Transport
Roads & Traffic
Authority

26 September 2011

DA 10_0209
LOT 519 DP 729020 - No. 19 BRISBANE WATER DRIVE, KOOLEWONG
EXHIBITION OF ENVIRONMENTAL ASSESSMENT FOR A PROPOSED 50 BERTH MARINA

PROJECT
PLAN TITLE
**PROPOSED CARPARK LAYOUT (44 SPACES)
TYPICAL SERVICE VEHICLE AND STANDARD
CAR TURNING TEMPLATES**

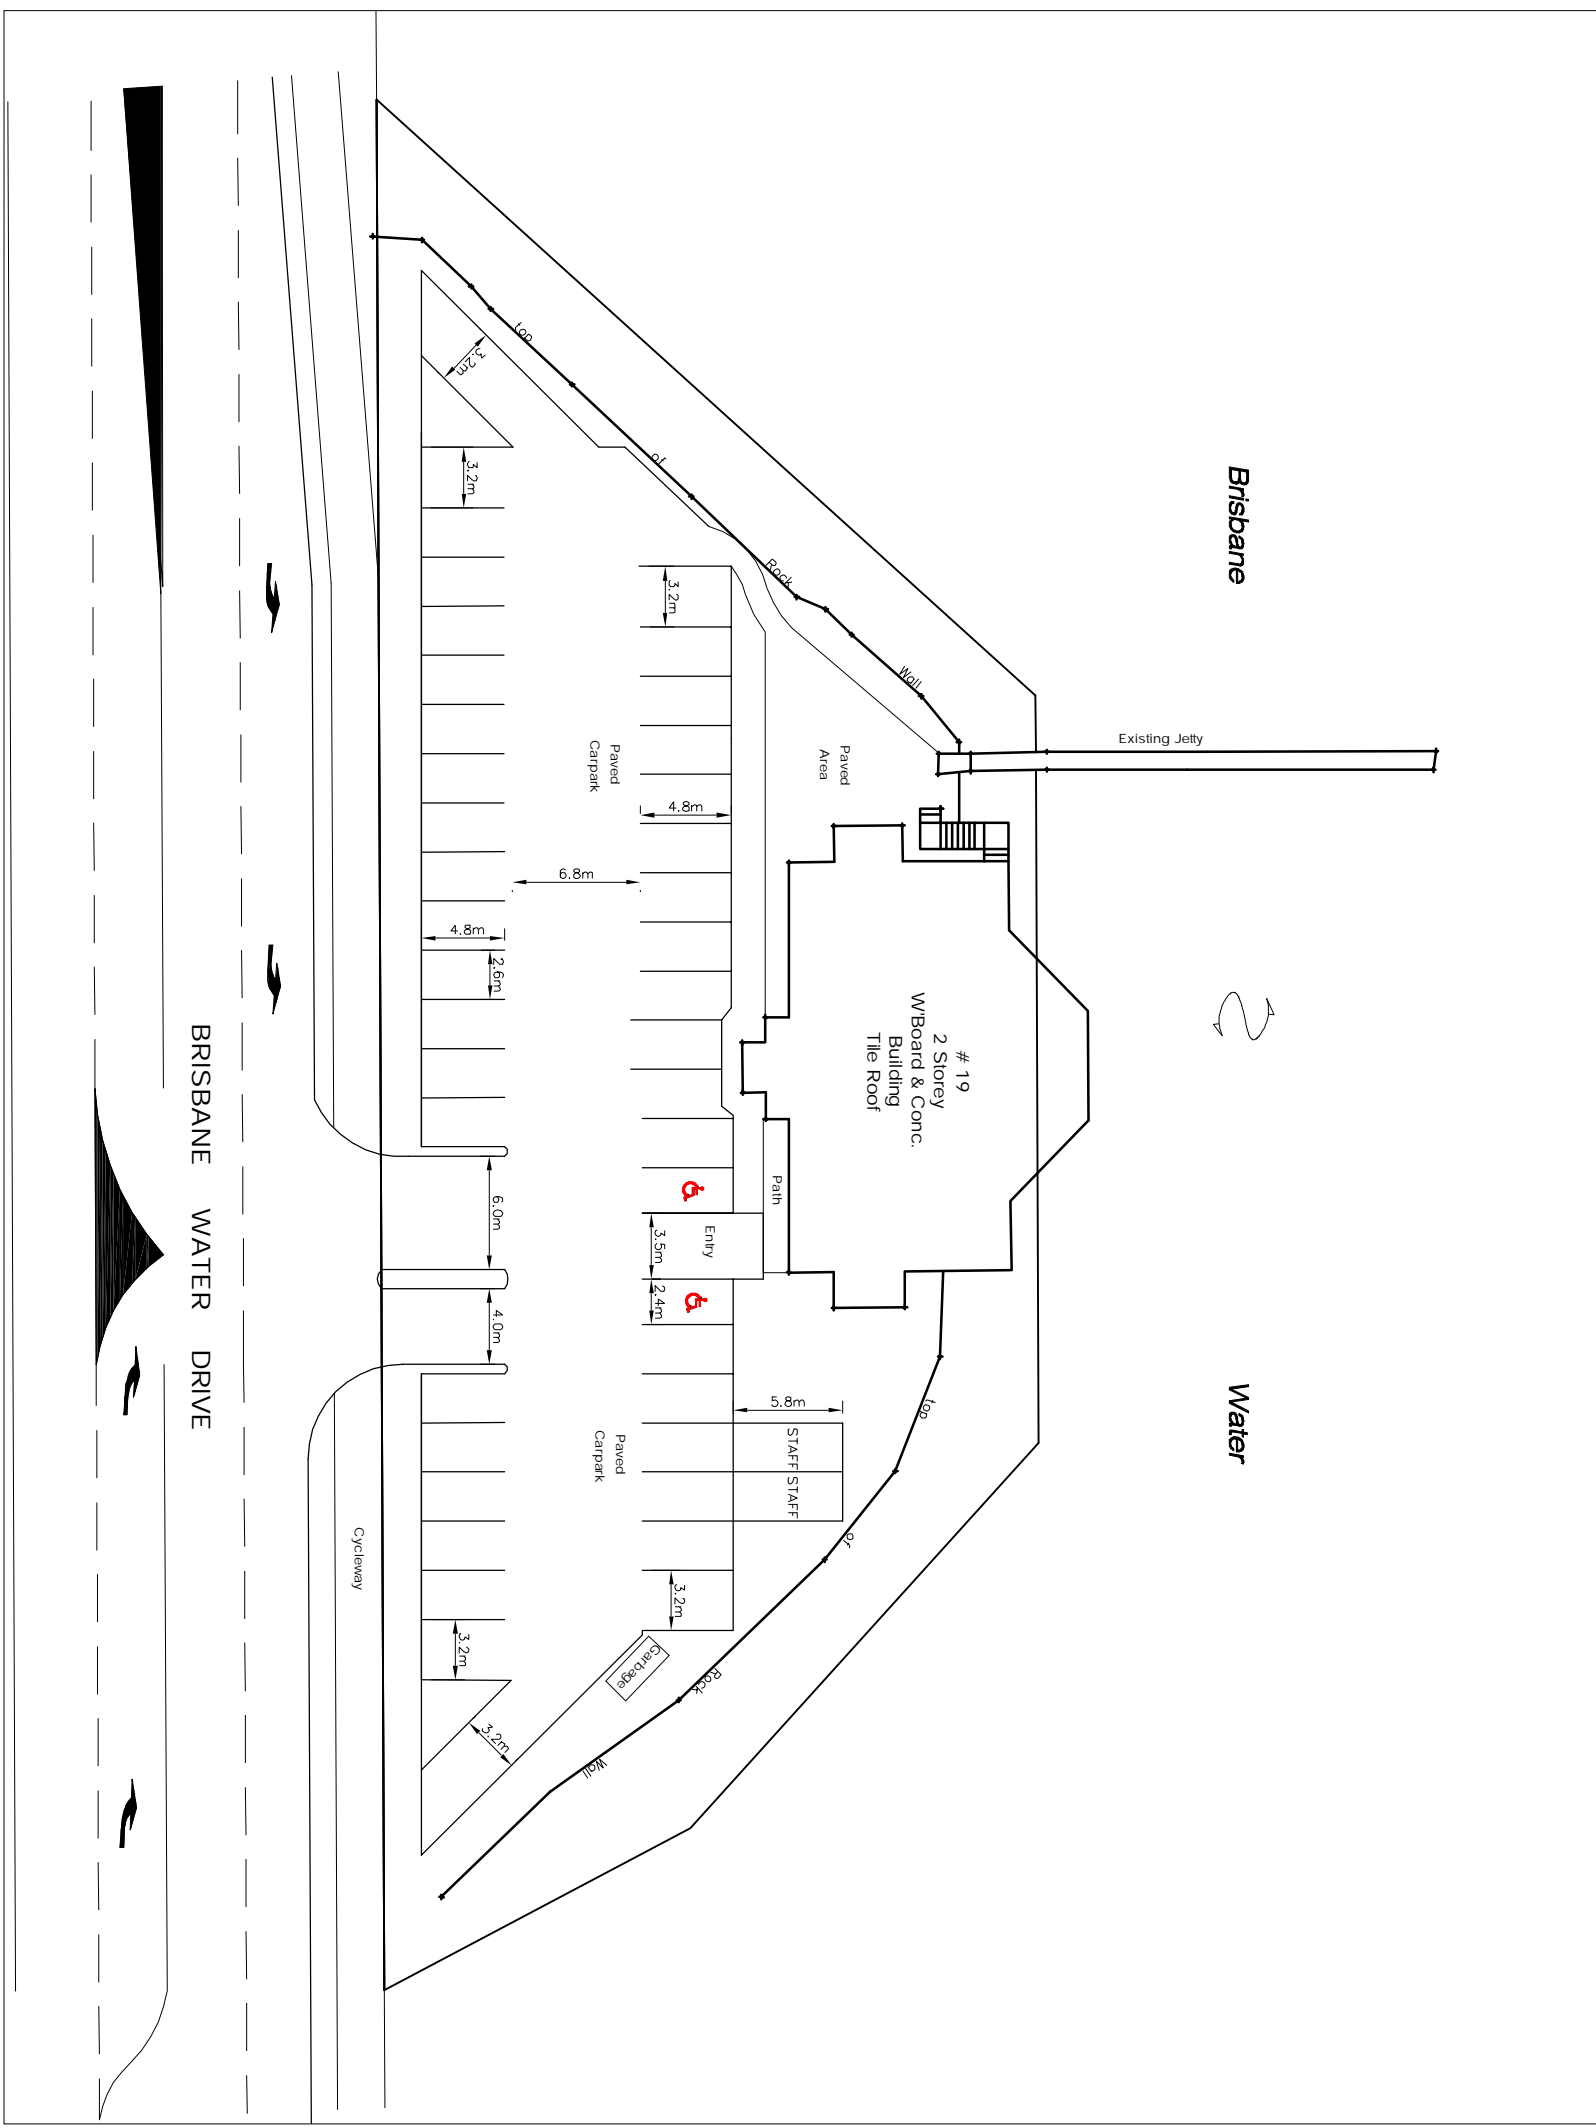
- On site vehicular turning facilities are to be provided to enable the largest design vehicle to enter and exit the site in a forward direction.

- The access driveways shall be designed and constructed in accordance with AS2890.1: 2004 'Off-street car parking' – see Tables 3.1 and 3.2 for guidance.
- Internal accesses and parking facilities are to be designed and constructed in accordance with Gosford City Council DCP No. 111 'Car Parking' and AS/NZS 2890.1: 2004: 'Off-street car parking' (see Table 1.1 and Figure 2.2 for guidance) and AS 2890.2: 2002 Part 2: 'Off-street commercial vehicle facilities'. In particular the developer shall ensure, given some parking space lengths are only 4.8m long, that the first 600mm immediately behind the end overhang of the vehicle is unobstructed by another parking space, a footway or similar, or vegetation.
